From: Simon Davis
Sent: 16 August 2019 11:00
To: Planning.Responses
Subject: FW: Nyton House care home dementia ward AL/42/19/PL & AL/43/19/L
Attachments: 18-003 210 P01 - Neighbour Impact 2of2.pdf; 18-003 203 P5 - Proposed Site Plan.pdf; 18-003 206 P5 - Proposed Elevations.pdf; 18-003 209 P01 - Neighbour Impact 1of2.pdf

Please see Action Sheets (AL/42/19/PL & AL/43/19/L)

1. View from Knighton Grange (At 1.8m Height)

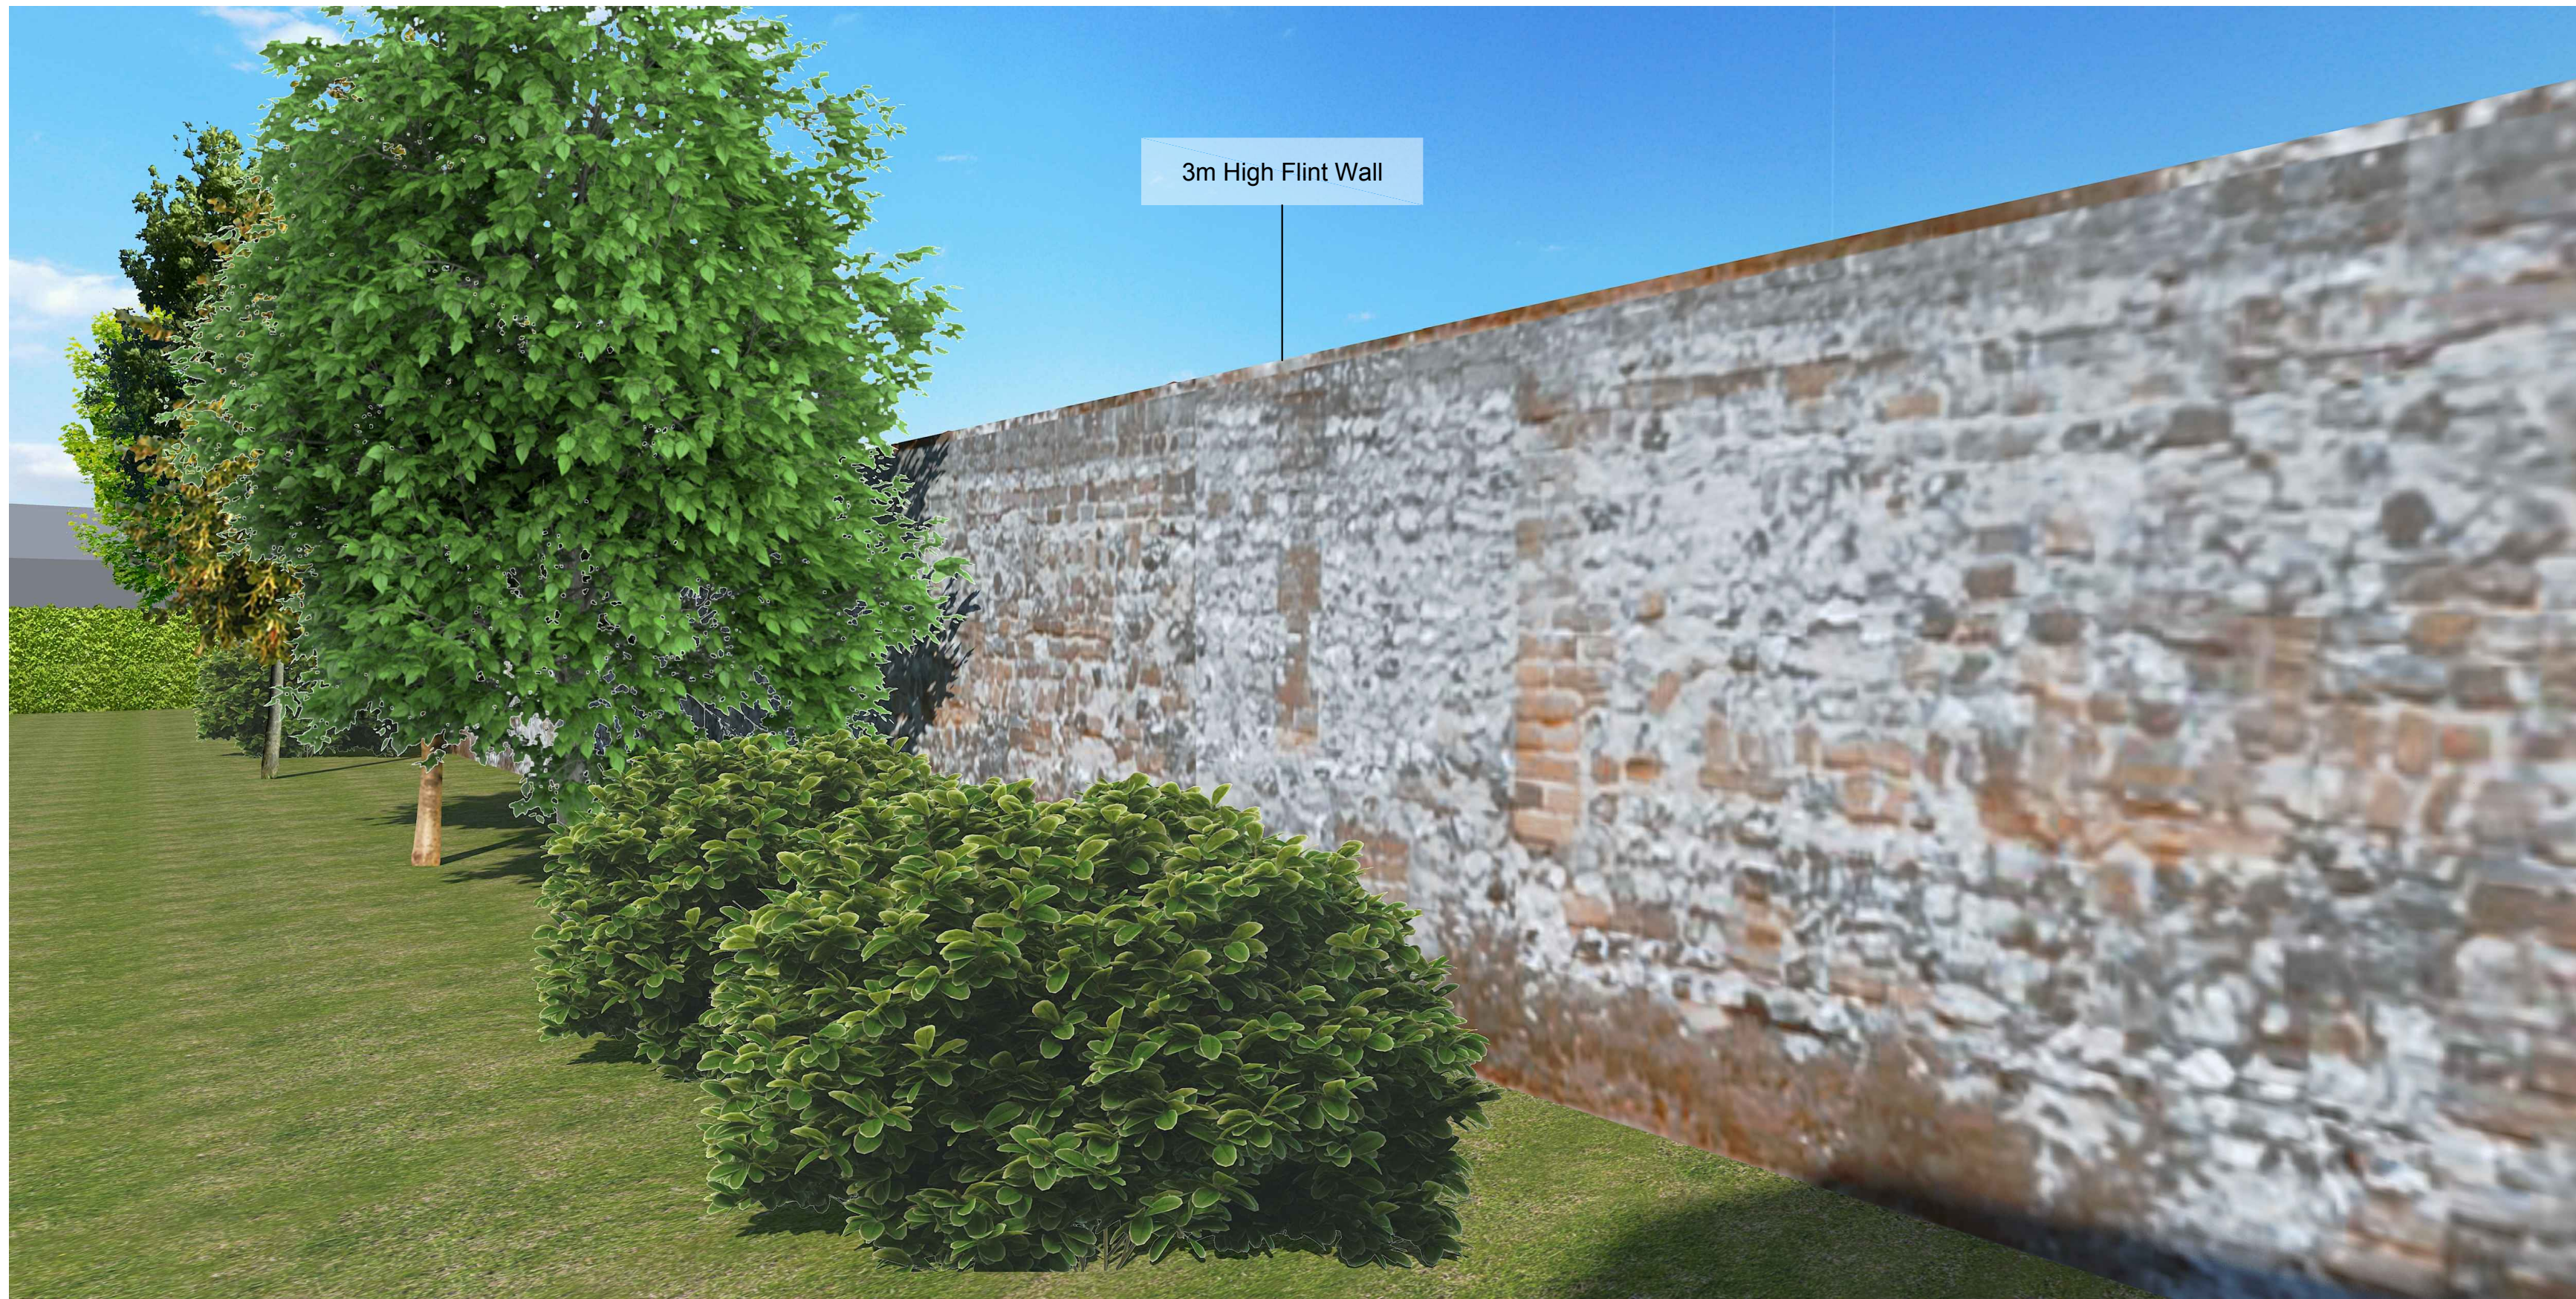
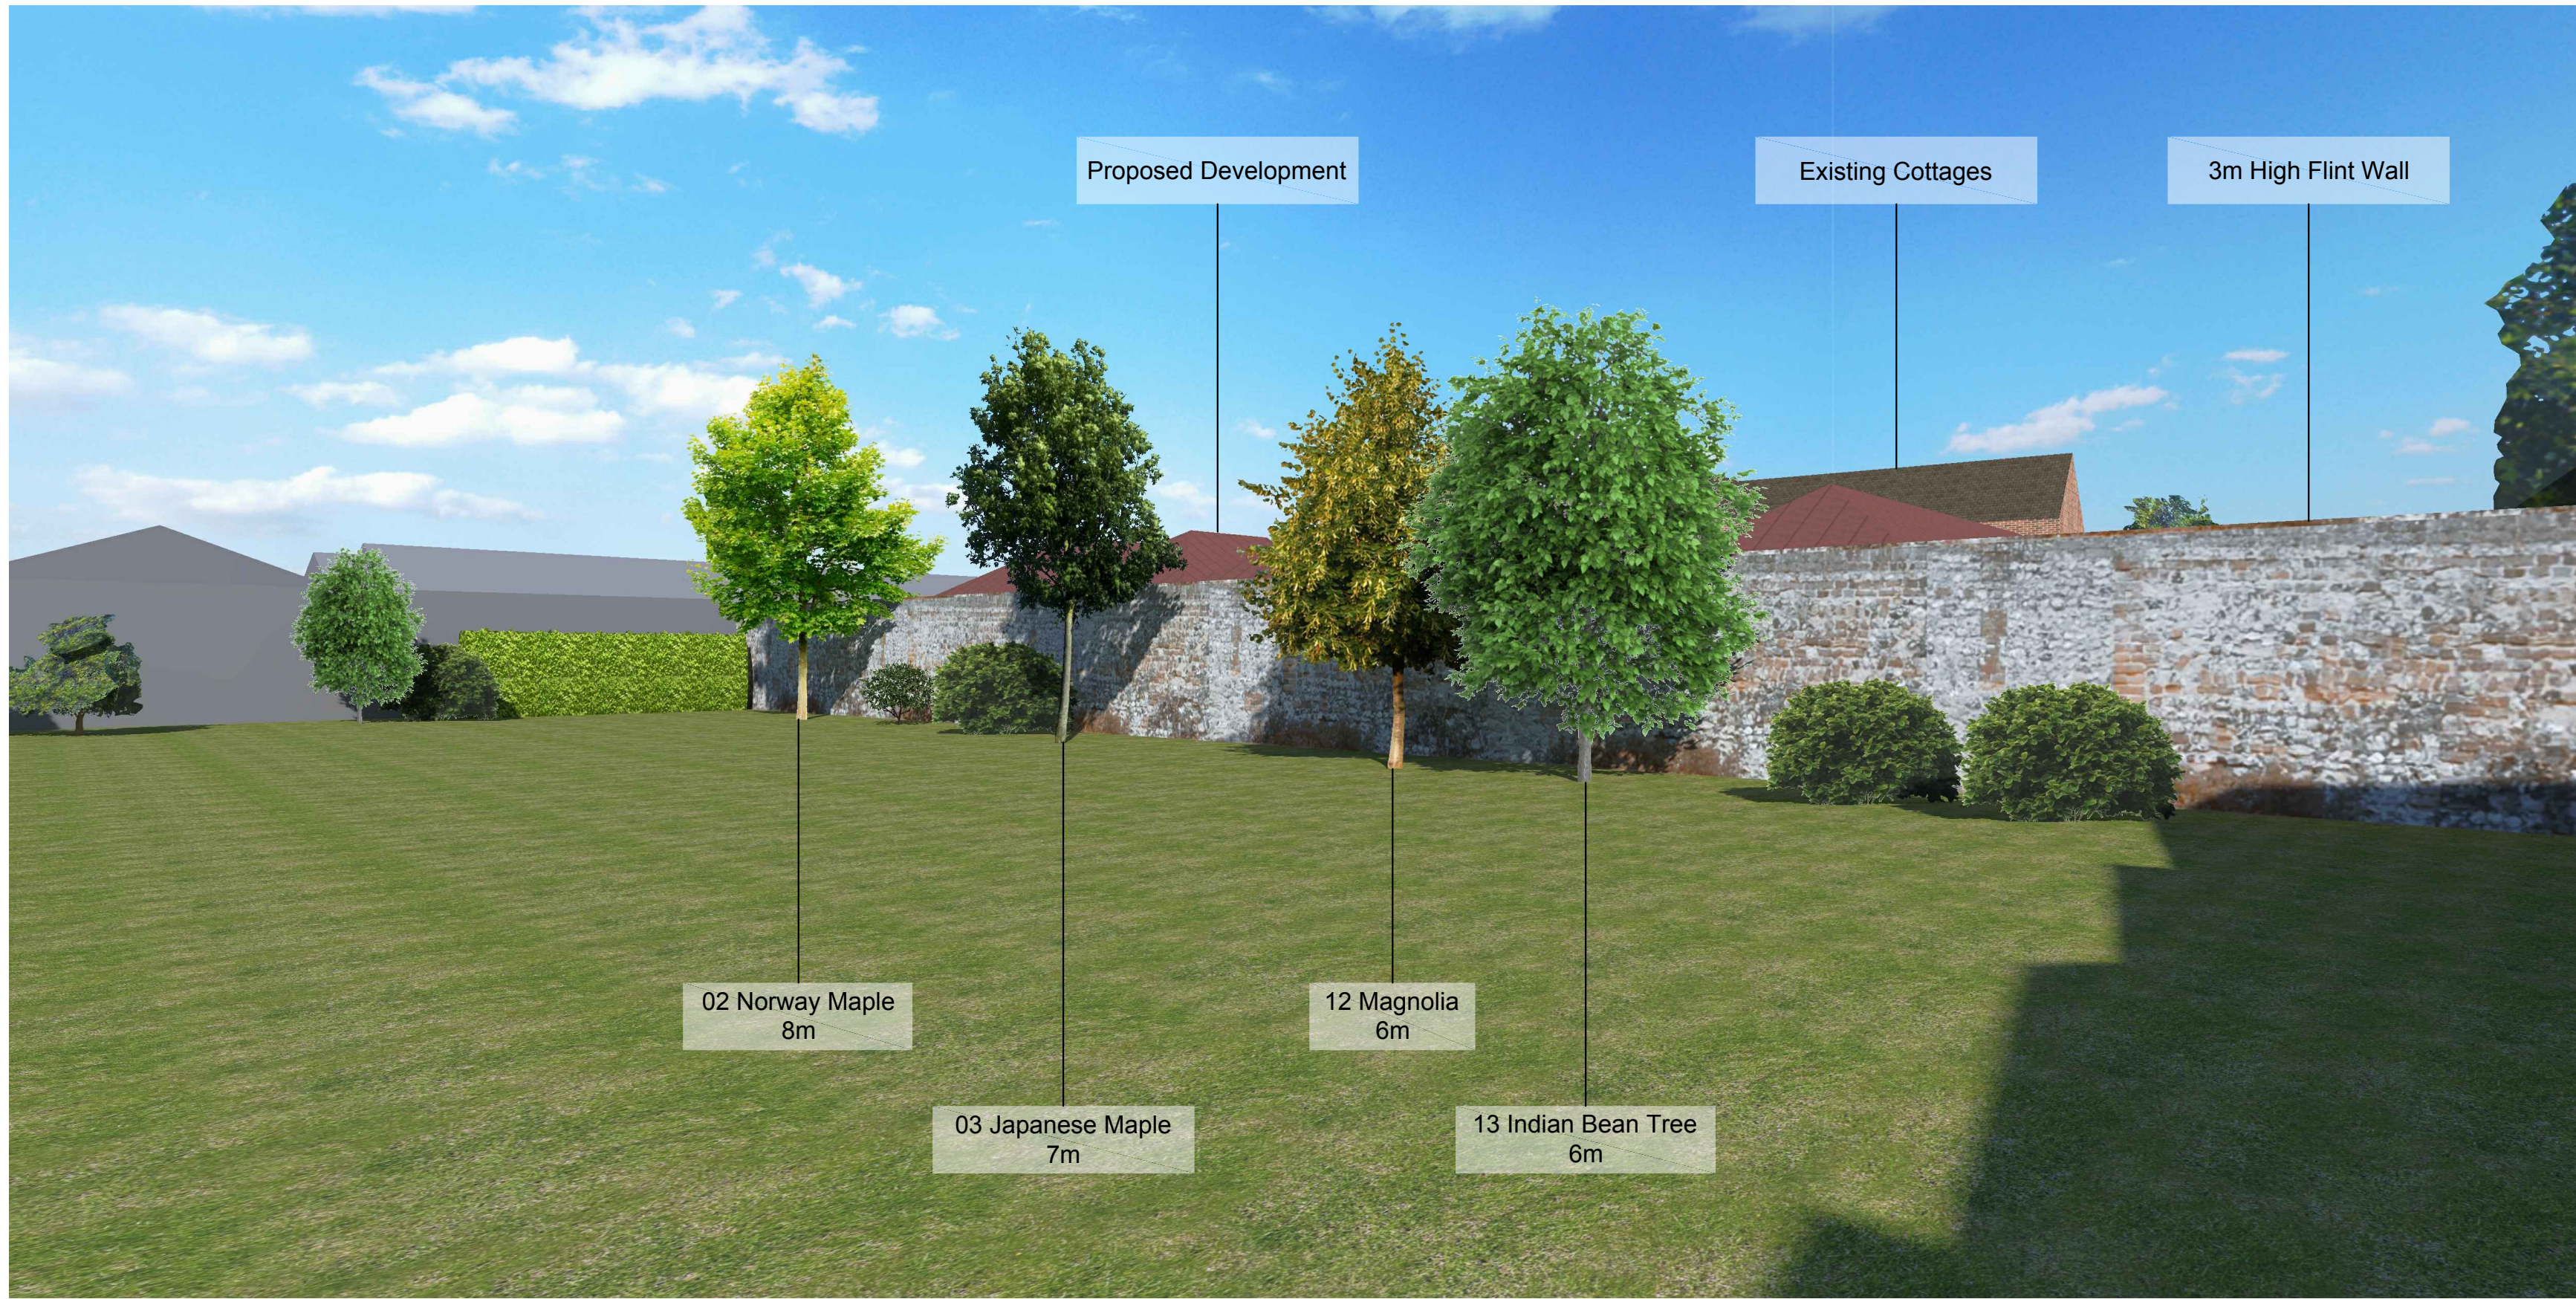
We would welcome the hipping of the western roof gables. This would also reduce the impact on the occupiers of Knighton Grange (they have partly objected to the impact on their view).

You may also wish to prepare some form of visualisation drawing to demonstrate what the view from Knighton Grange would be? This could help at Committee.

You will see that we have altered the roof form of the new dementia wing in order to pull the apex gables away from the 3m high flint wall boundary with Knighton Grange. In addition we have prepared elevations and views which demonstrate that not only is the impact negligible, it is also no different to the impact on the setting of the neighbour by the existing buildings at Nyton Cottages and Nyton House.

I'd be happy to prepare that image and agree that it will be of huge use in demonstrating the aspect from Knighton Grange
